STATE OF NORTH CAROLINA  
DEPARTMENT OF TRANSPORTATION

**Addendum No. 1**

RE: Contract ID C202690  
WBS # 12CR.018093, etc.

**Catawba County**

TYPICAL SECTION NO. 5

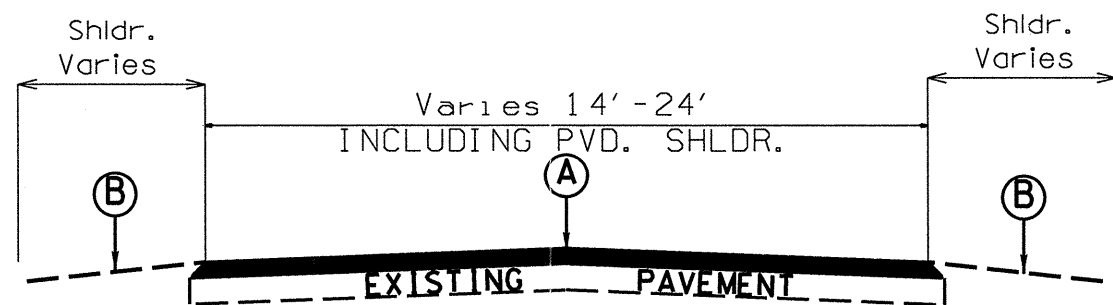
On Sheet No. 12, Typical Section No. 5 has been revised to add "Milled Rumble Strips". Please void Sheet No. 12 in your sketch maps and staple the revised Sheet No. 12 thereto.

ENGLISH STANDARD DRAWING FOR
ASPHALT SHOULDERS
MILLED RUMBLE STRIPS

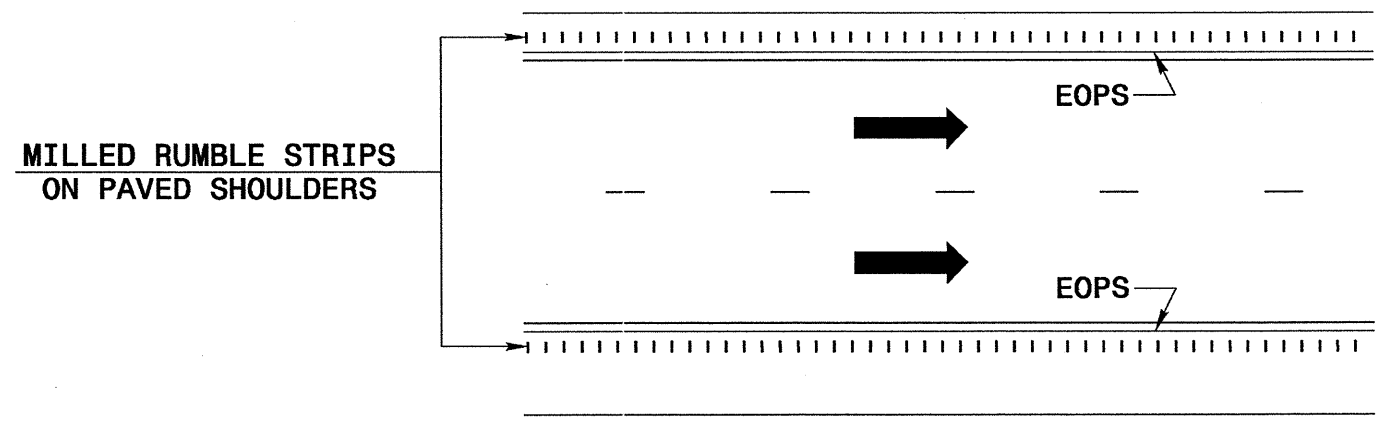
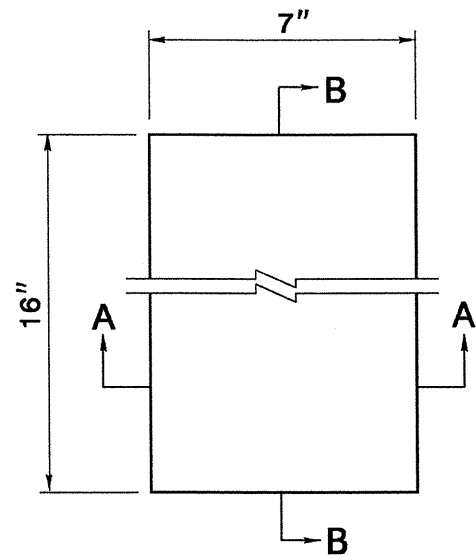
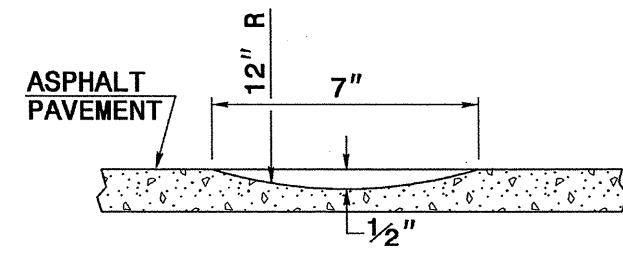
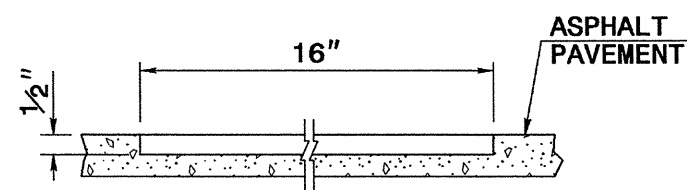
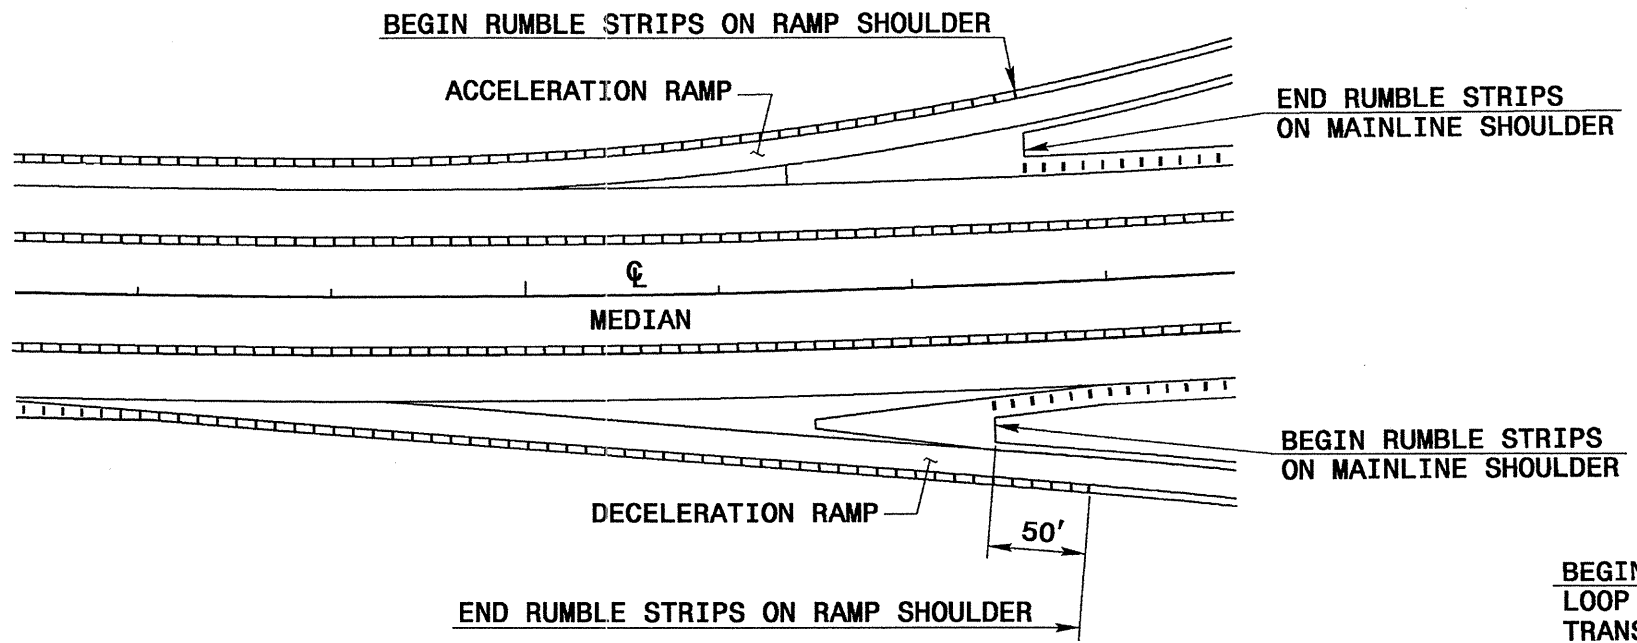
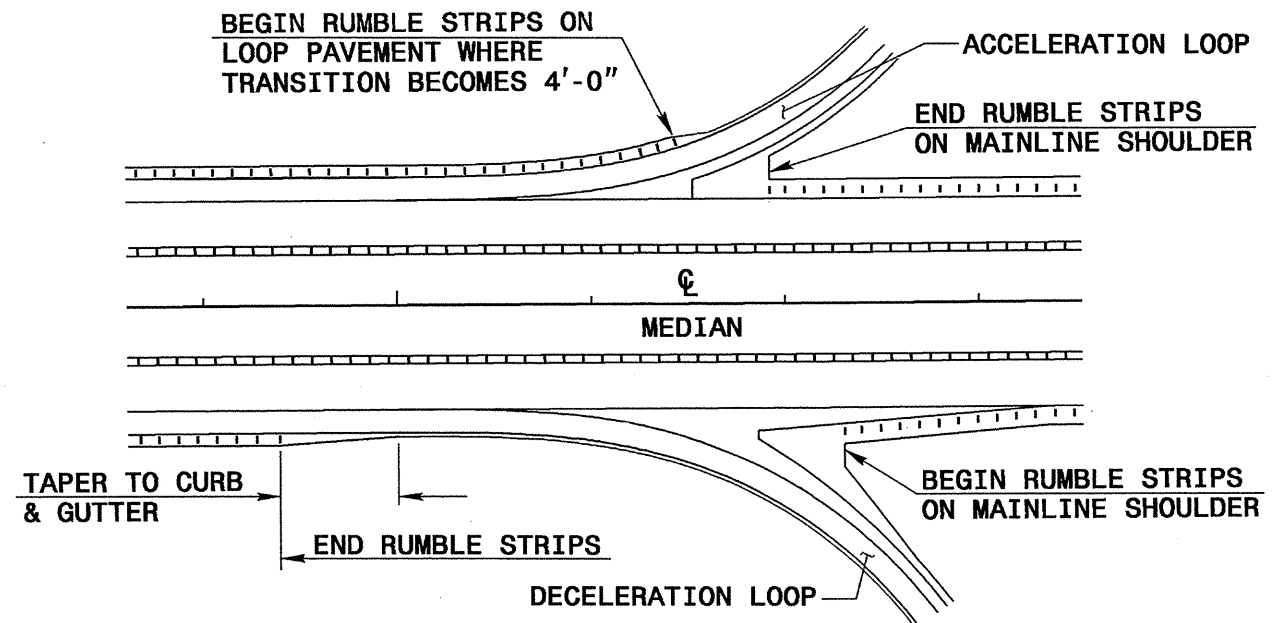
New Sheet Nos. 18 and 19 were added to include the Detail for "Milled Rumble Strips". Please staple new Sheet Nos. 18 and 19 after Sheet No. 17 in your sketch maps.
